Our Ref: A/165/19/DOC

Approval of details reserved by condition imposed under ref A/74/18/OUT relating to Condition Nos 4 - acoustic, 5 - external lighting, 7 - contamination, 12 - hedgerows, 14 - surface water drainage, 15 - discharge of flows, 16 - SuDs and 18 - watercourse or culvert.

The Laurels Dappers Lane Angmering BN16 4EN

Arun District Council have decided to **REFUSE details reserved by condition for the following reasons:**
The submitted information is not sufficient to discharge the condition.

- Figure 1 Site Location Plan
- Figure 2 Remedial Works Plan

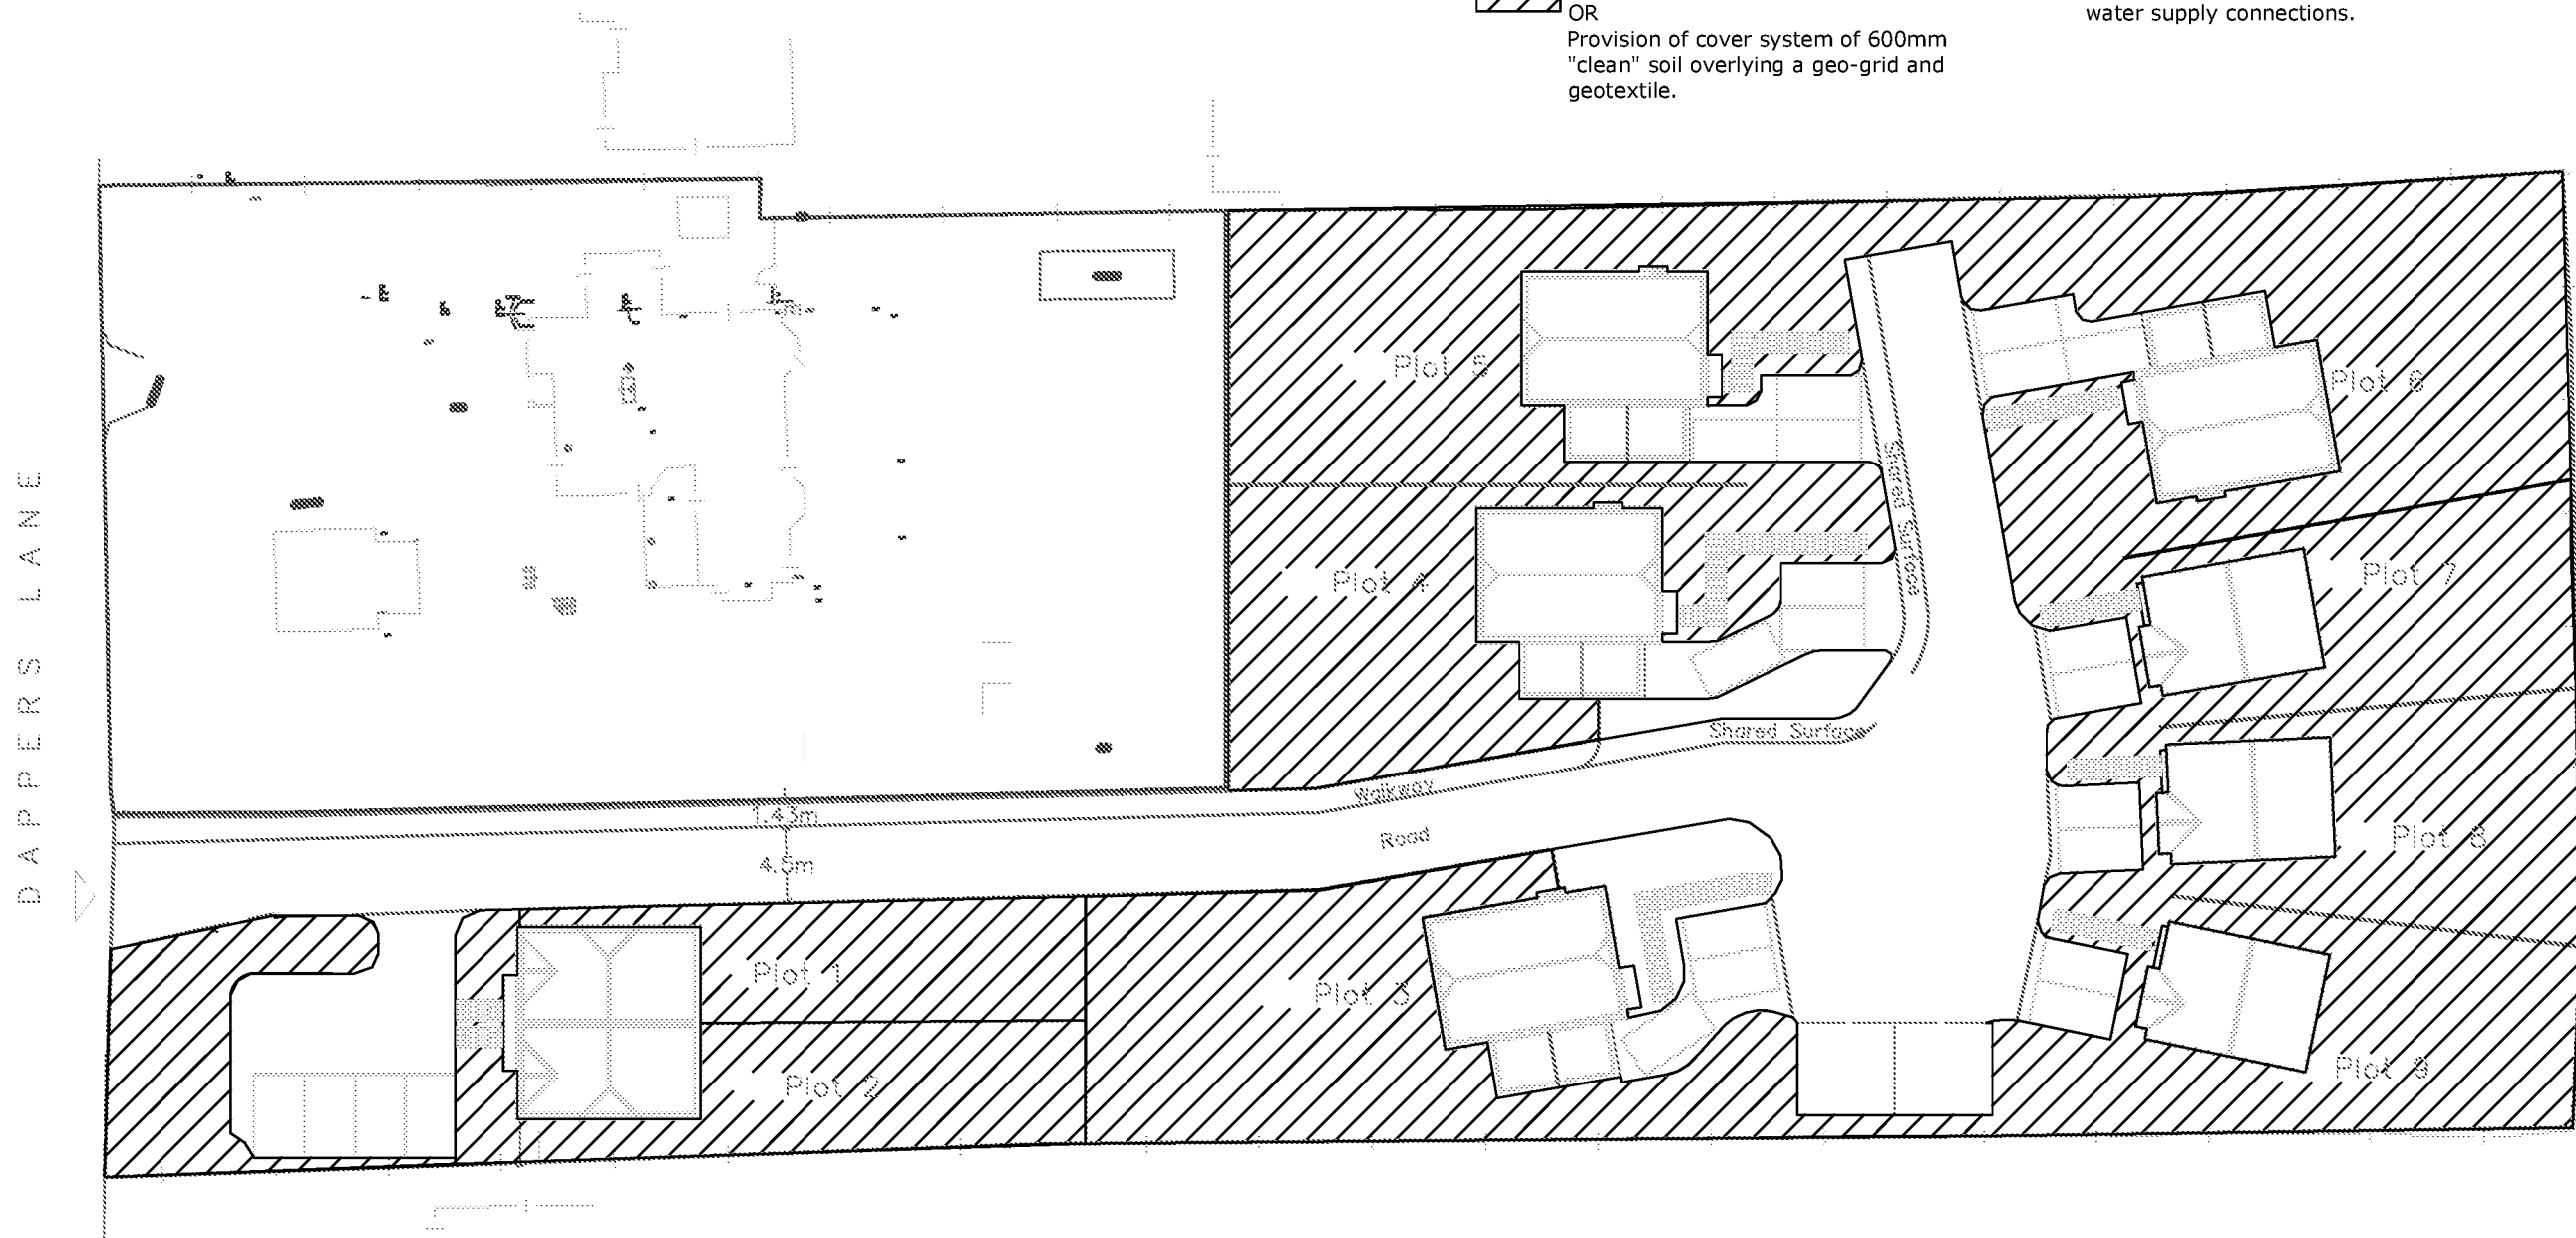
Having reviewed Ashdown Site Investigation Limited, Geo Environmental Data and Historic Maps (ref.: R18-13291, dated October 2018), Ground Contamination Risk Assessment Report (ref.: R 1813291, dated November 2018) and Remediation Strategy (ref.: R13936, dated October 2019), the Environmental Health Officer has advised condition 7 cannot be discharged because part 4 of this condition remains outstanding.

- which of the remedial options will be followed/whether a combination of these options is proposed/whether a different remediation strategy will be deployed;
- the data that will be collected to demonstrate the remedial work is being achieved;
- details of any long-term monitoring required.
